From:
Sent: 15 October 2019 09:30
To: DCAdmin
Subject: FW: Objection to planning Application Number 2019/91141
Attachments:

Please be aware that the previously approved application had inaccurate plans
This application has replicated those inaccuracies. The proposed plans do not represent a true and accurate surrounding built environment.

Drawing FRONT ELEVATION
INDICATIVE HEIGHTS

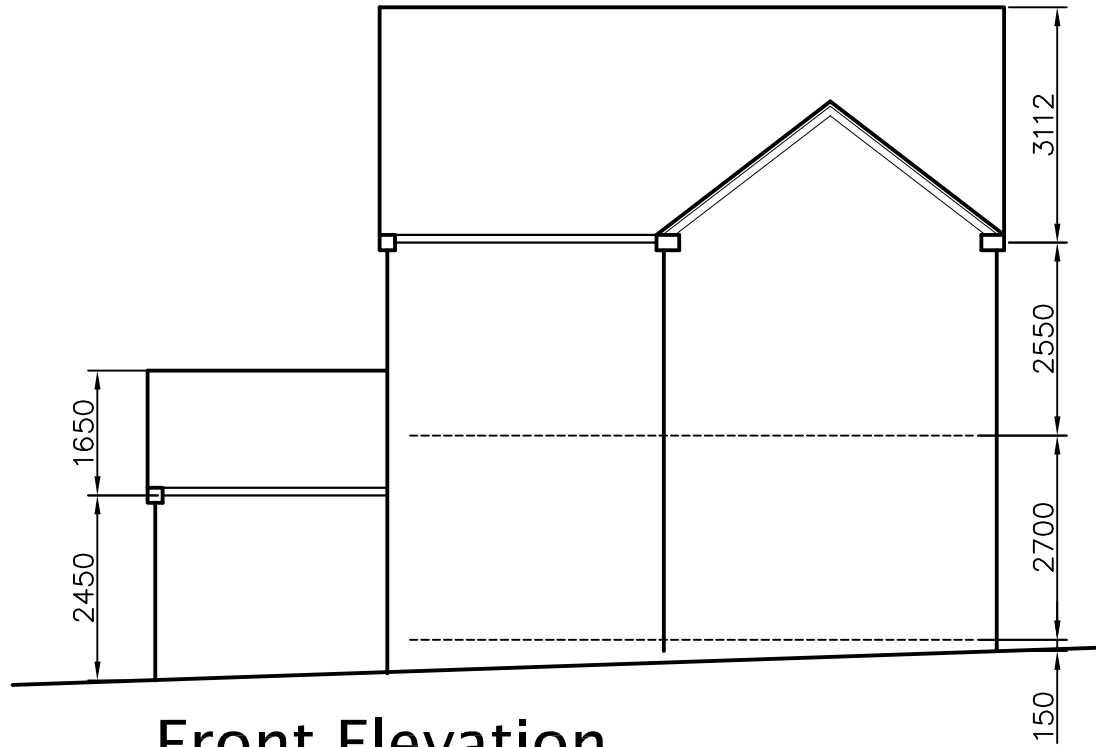
We understand that this is outline application however, we feel that the positions of any windows on the upper floor should form part of this application as both the design of the property and the effect it has on the surrounding properties is a fundamental point of concern for all parties involved. We also request that a full and proper plan for sustainable drainage and water runoff be submitted and approved prior to any commencement of any works due to on-going drainage issues, which continue to cause considerable concern.
